## CWWTPR DCO Examination

SHH 41

## Submission by Save Honey Hill Group

## ISH3 - Environmental Matters, Day 2, 11 January 2024: Summary of Oral Submissions

E.7 Total Phosphorus Heat Map Modelled Proposed Interim Permit

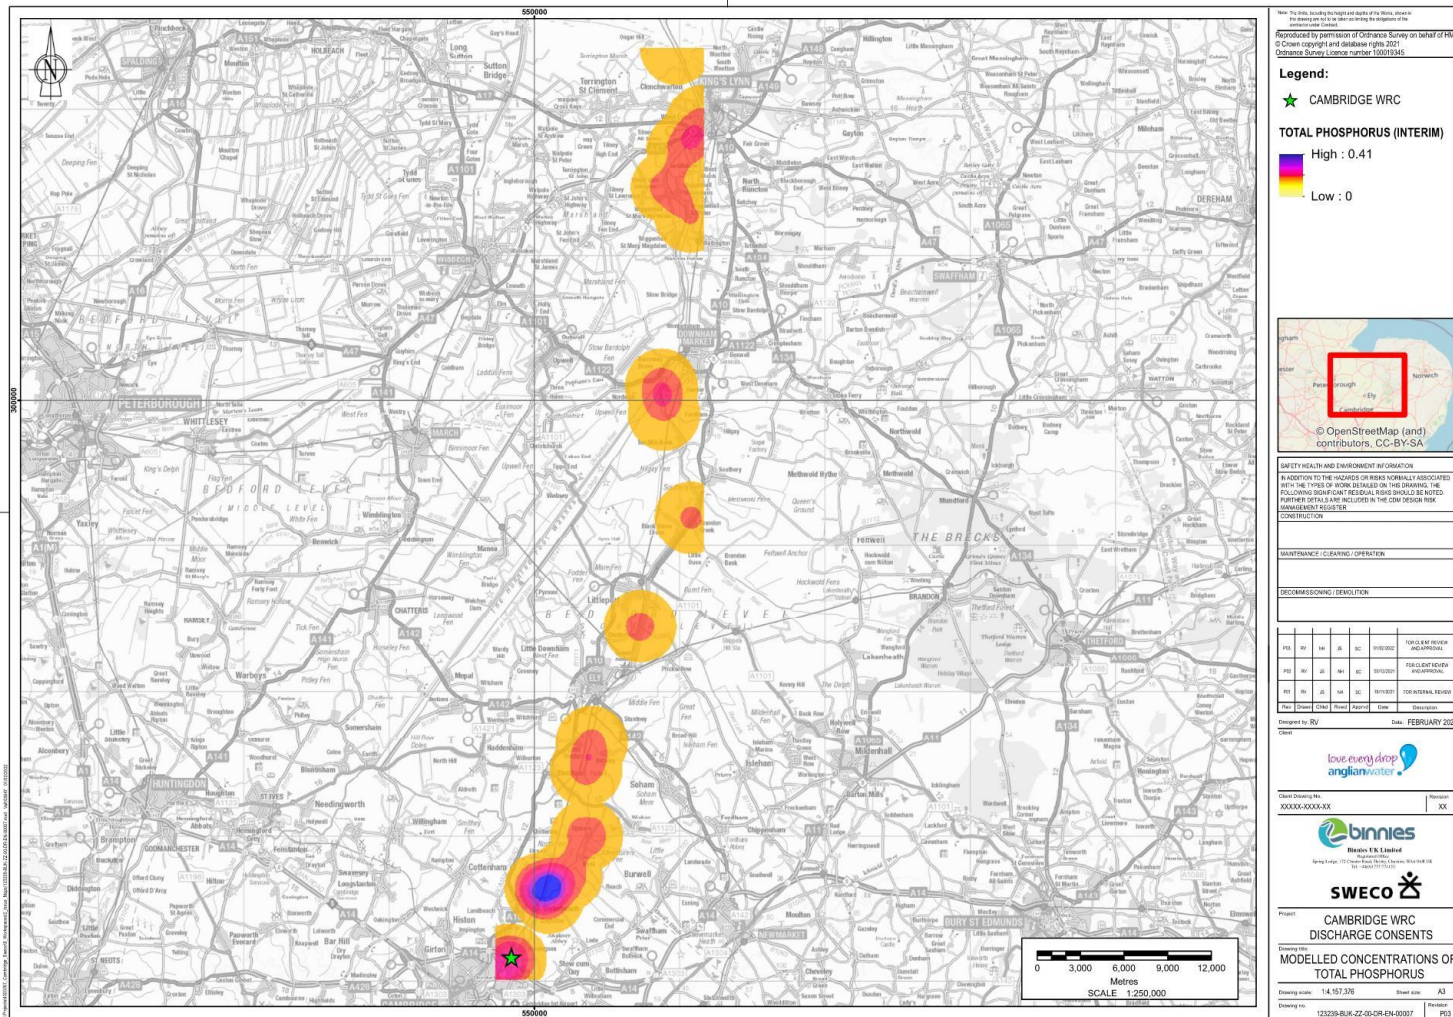
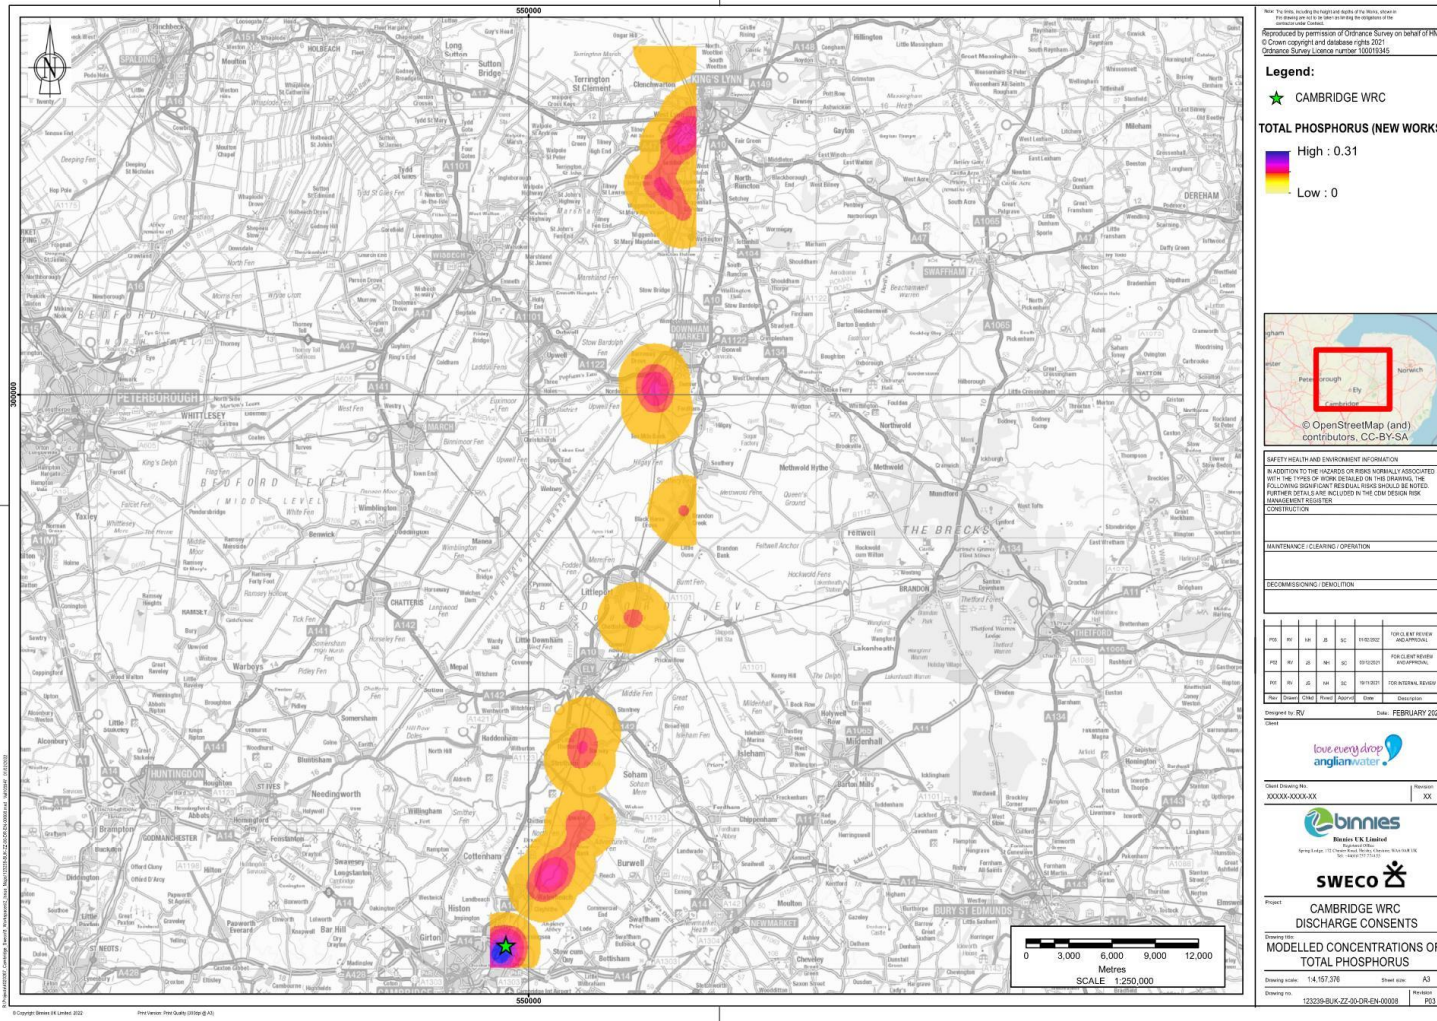
- 6.1 Effects on water quality: SHH notes the Applicant's claim that effluent loads from the new works are a substantial improvement over those from the existing works. That may narrowly be true, in terms of effluent total loads, but the Applicant has not demonstrated that through up-to-date water quality modelling, nor has the Environment Agency signed off that assessment. Later in questioning, the Applicant admitted that it has not modelled water quality at discharge parameters that it is seeking in the final effluent permit under conditions of low flow taking account of climate change. In consequence, the Applicant accepts that there is no certainty that there will for example be phosphorus levels in say 2050, which are better or worse than at

- 6.3 SHH noted that the Applicant is to respond in writing to SHH's concern about higher than acceptable phosphorus/BOD and suspended solids arising in the reach of the Cam between the new outfall and Bottisham Lock. If there is new modelling to support the Applicant's position this should be produced.
